Consultation Response from: KC Environmental Health (Pollution & Noise Control)
2025/90557 - 101 New Street, Huddersfield, HD1 2TW
Alterations to first floor store to form 4 student flats
Responding Date:
11 August 2025
Responding Officer:
Mohammed Nasim
Responding Ref:
WK202524125
Comments
Odour

South Elevation as Proposed

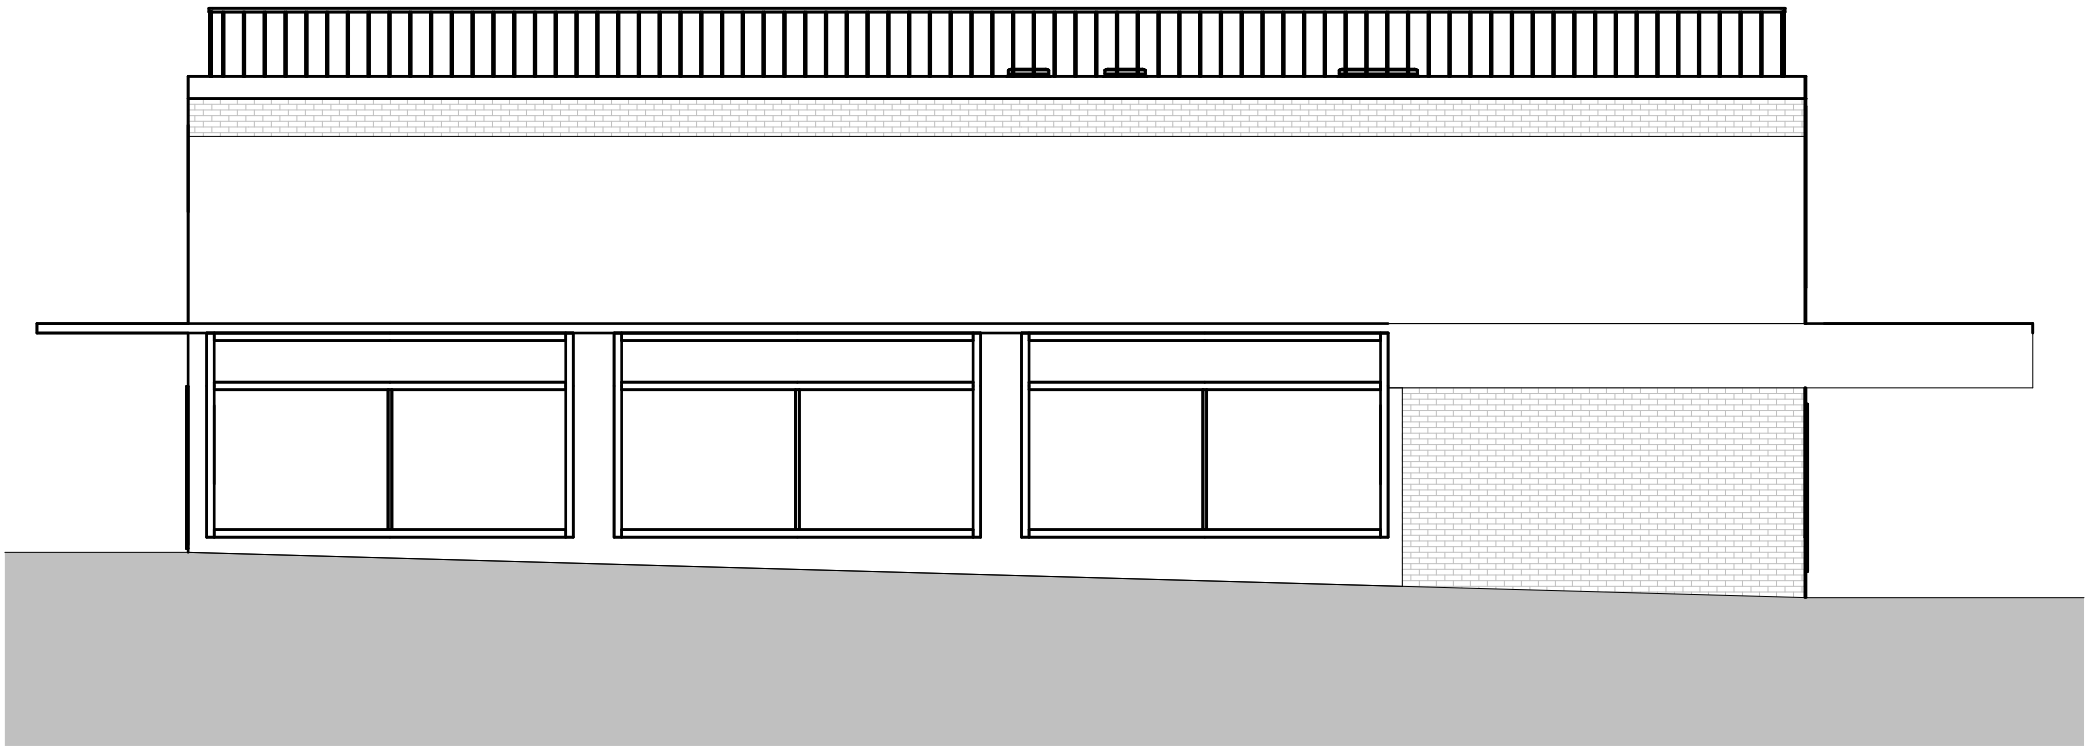
The proposed development is situated within an Air Quality Management Area, it is possible that it will introduce sensitive receptors into an area of known poor air quality. The façade on Peel Street is just above a ramped entrance to an underground delivery car park.

Before the development is brought into use an Air Quality Screening Assessment shall be submitted to and approved in writing by the Local Planning Authority. The assessment shall determine the impact that the poor air quality in the area will have on the future occupiers of

the proposed development and provide details of any necessary mitigation measures that will be provided to address any such adverse impact. The approved mitigation measures shall be implemented within 3 months from the date of approval and retained thereafter.
